Consultation Response from KC, Highways Development Management
2023/93759 12, George Street, Ravensthorpe, Dewsbury, WF13 3LL
Change of use from storage to garage, erection of single storey side extension and formation of vehicular access
Date Responded: 19.02.2025 Responding Officer: D. Stainsby Responding Ref: K14-4SW/1

This revised application is for a change of use from storage to garage, erection of single storey side extension and formation of vehicular access at 12, George Street, Ravensthorpe, Dewsbury, WF13 3LL.

DRAWING STATUS FOR APPROVAL		DRAWING No A1-CAD/02D	
DRAWN	MAMJID	DATE	24/03/2025
SCALE	1:100 @ A1	REVISION	D

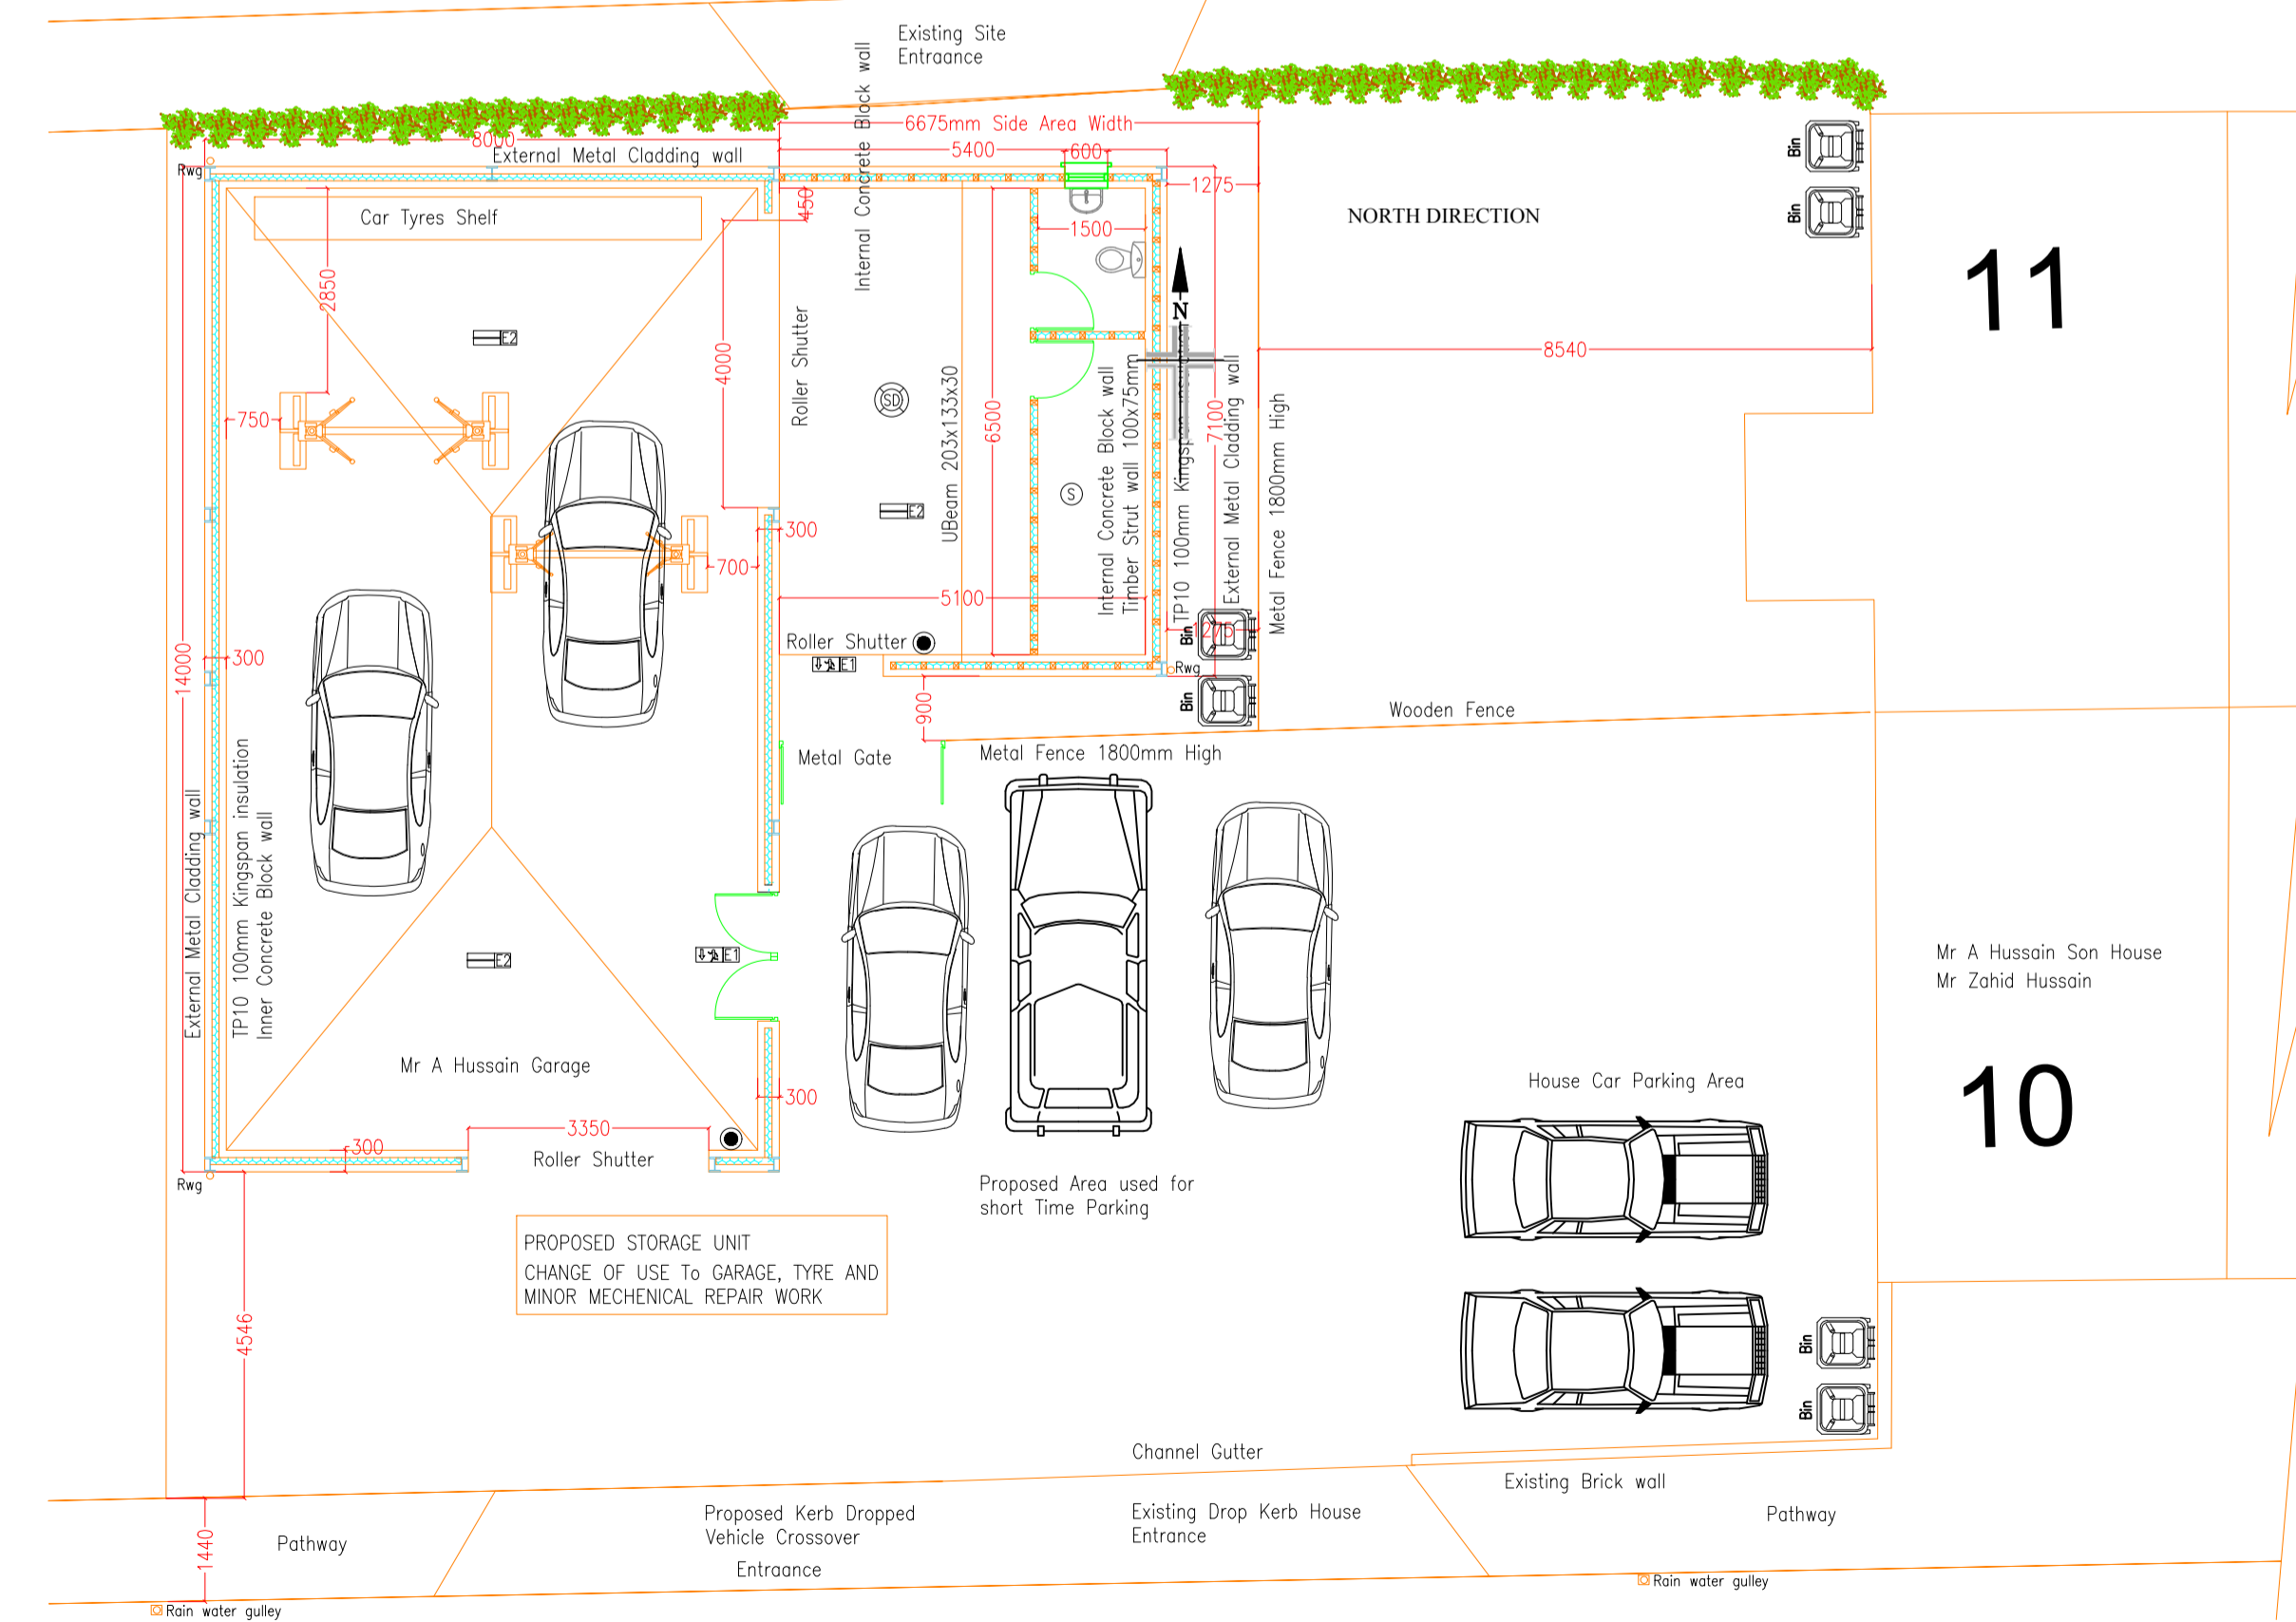
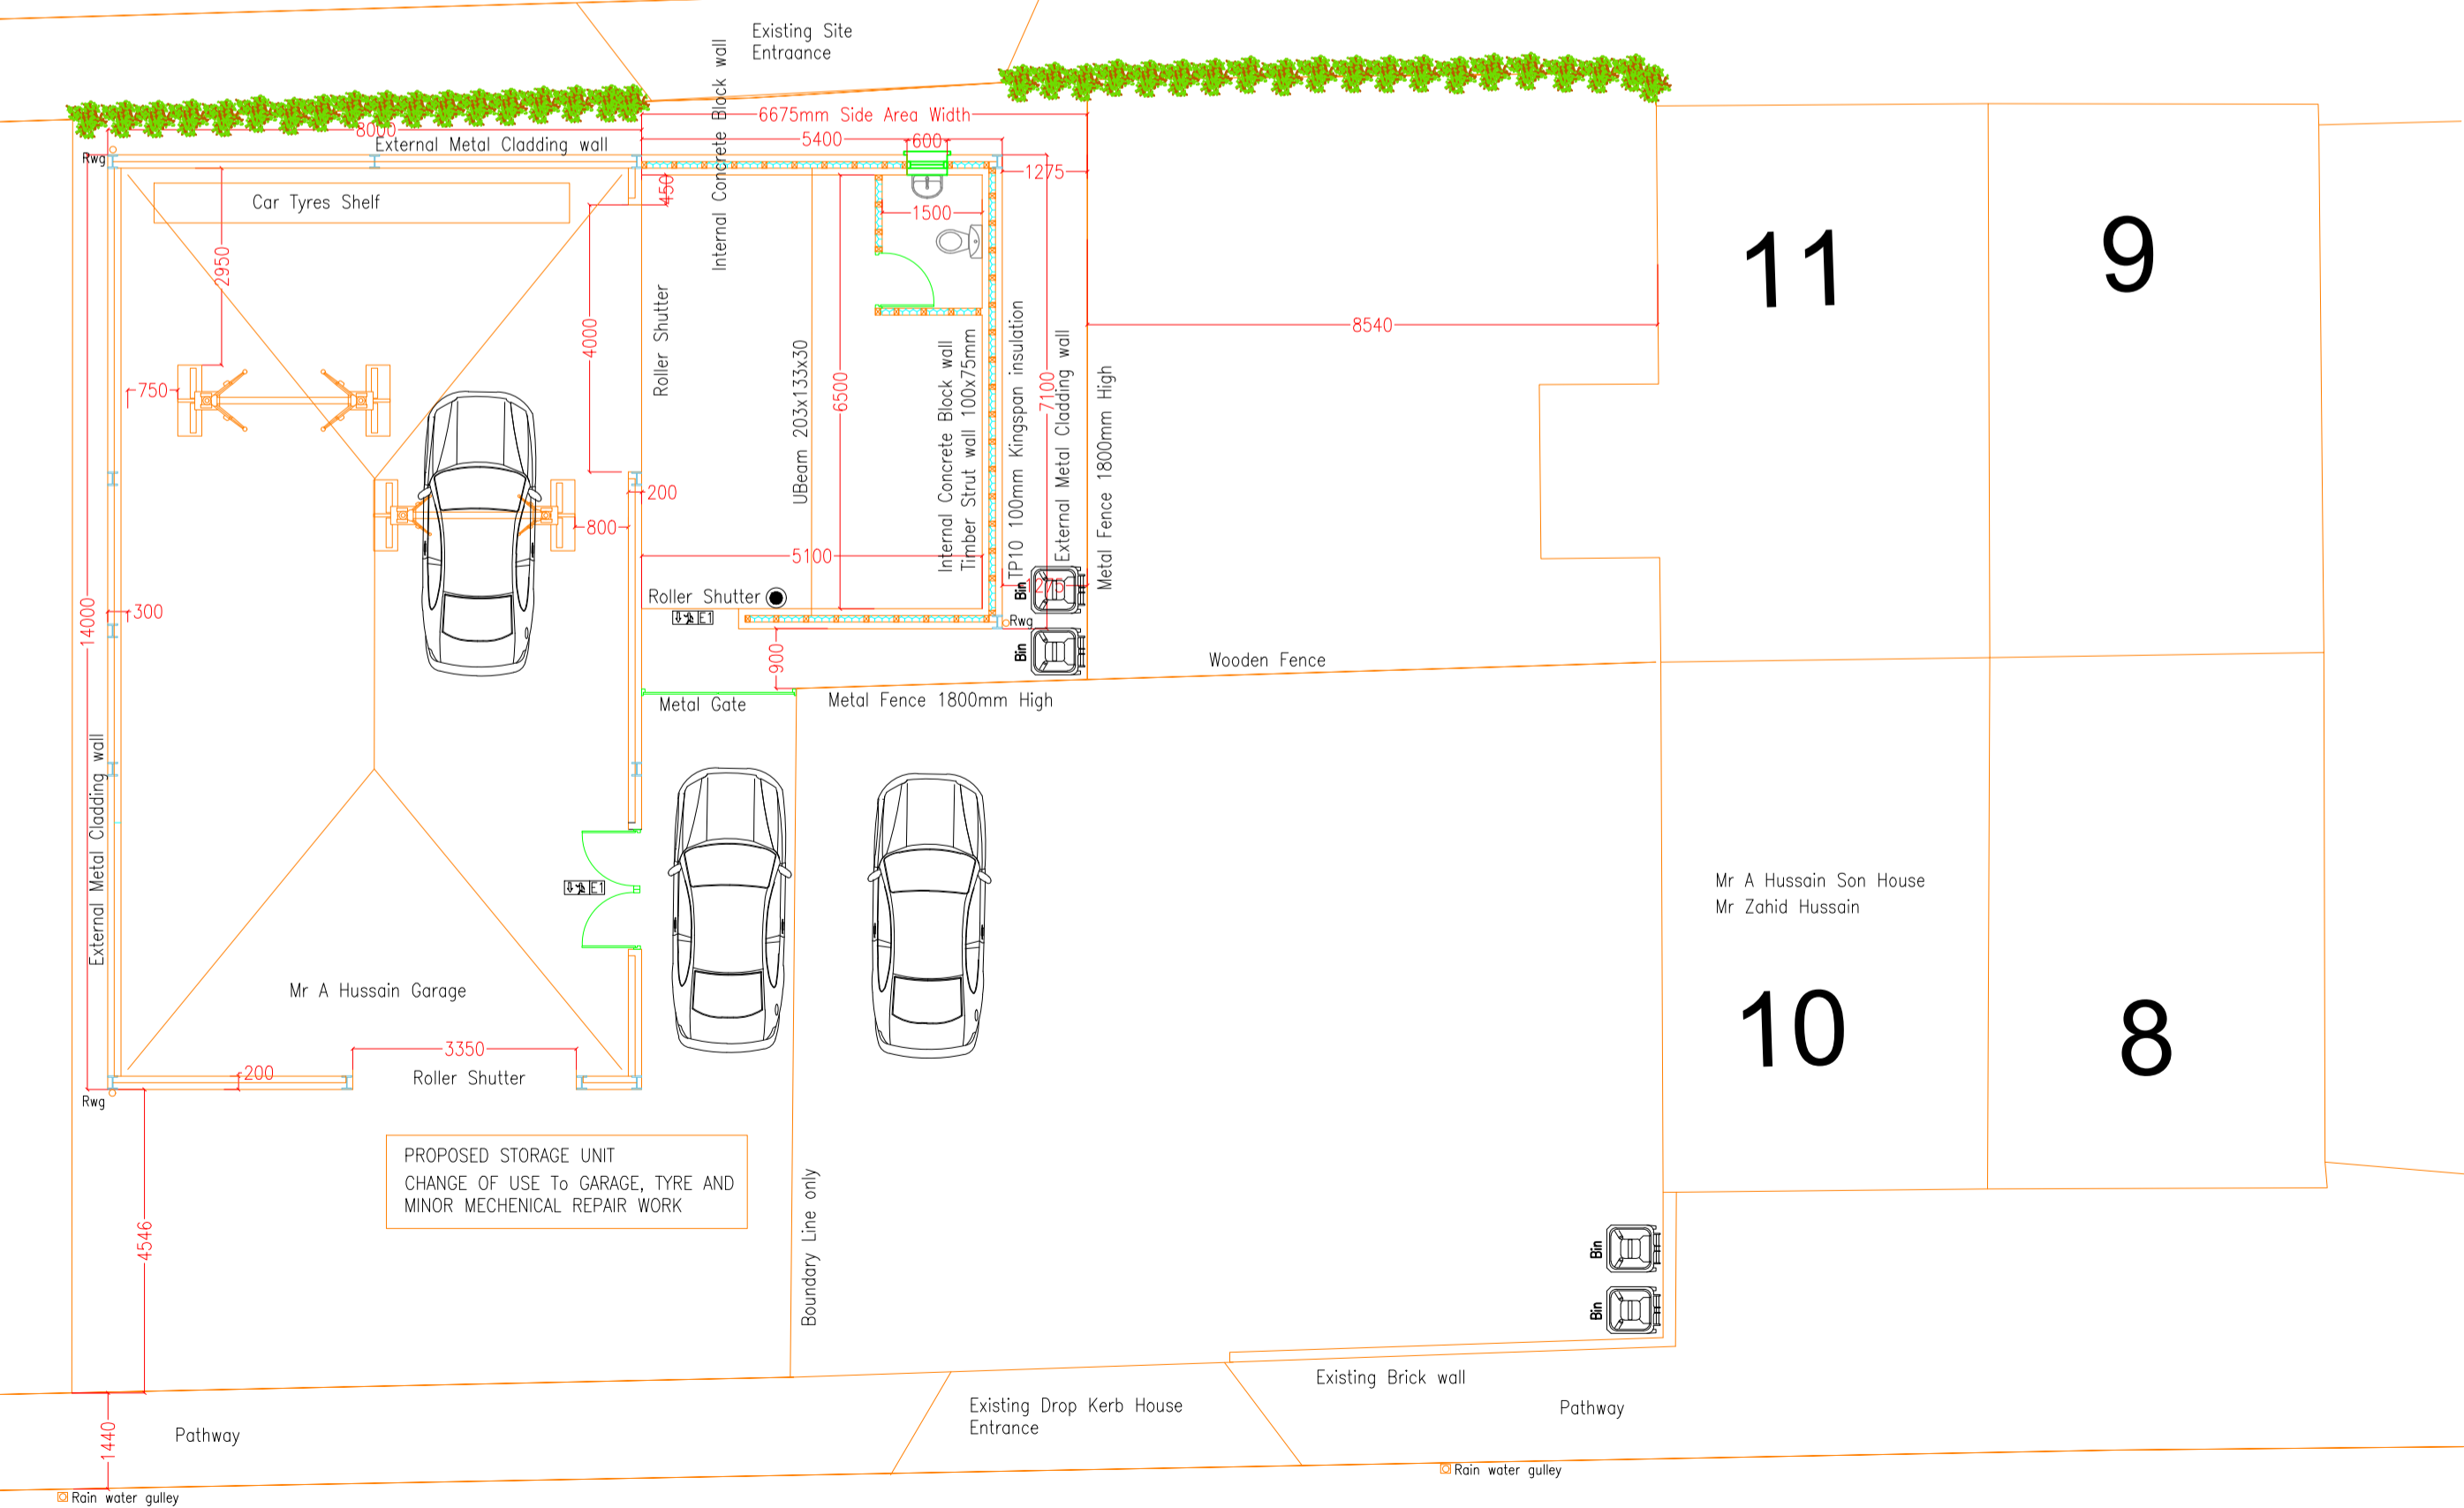
- A revised plan showing the replacement parking for No 11 George Street needs to be provided.
- A revised plan showing a suitable waste/storage area on the site together with a bin storage area for No 11 George Street needs to be provided.
- A revised plan showing the dropped kerb extending across the whole of the site frontage needs to be provided.

The new vehicle access proposed from George Street has been widened. But this does not still extend across the whole of the frontage to provide vehicle access to the proposed parking area on the site frontage on George Street.

A revised plan showing the dropped kerb extending across the whole of the site frontage needs to be provided.

A telegraph pole is located on the site frontage. To achieve an acceptable access to the site, this may require relocating.

The parking/yard area is proposed within the neighbouring land owned by No 11 George Street.

Currently No 11 George Street has off street parking which will be removed by this application. No alternative provision is proposed to replace the loss of this off-street parking. This parking will need to be provided elsewhere on the application site.

The proposal shows that there is potential for approximately 5 vehicles within the parking/yard area which is acceptable for the proposal. However, the applicant will also need to show the replacement parking for No 11 George Street and the waste/storage area for the proposed garage which will ultimately reduce the available parking for the proposal.

The parking area on the site forecourt fronting onto George Street is still too small to accommodate any vehicles without them overhanging the public footway and causing an obstruction to pedestrians.

The depth of the forecourt will need to be extended to a minimum of 5.0m from the back of the adopted footway into the site for this area to be able to accommodate parking safely.

The proposed plan still shows only two typical residential waste bins on the site.

Bearing in mind that the proposed use is for a garage and tyre repair centre the waste/storage area will need to be increased substantially, and the proposed size and location demonstrated on a plan.

A separate bin storage area will need to be provided for No 11 George Street
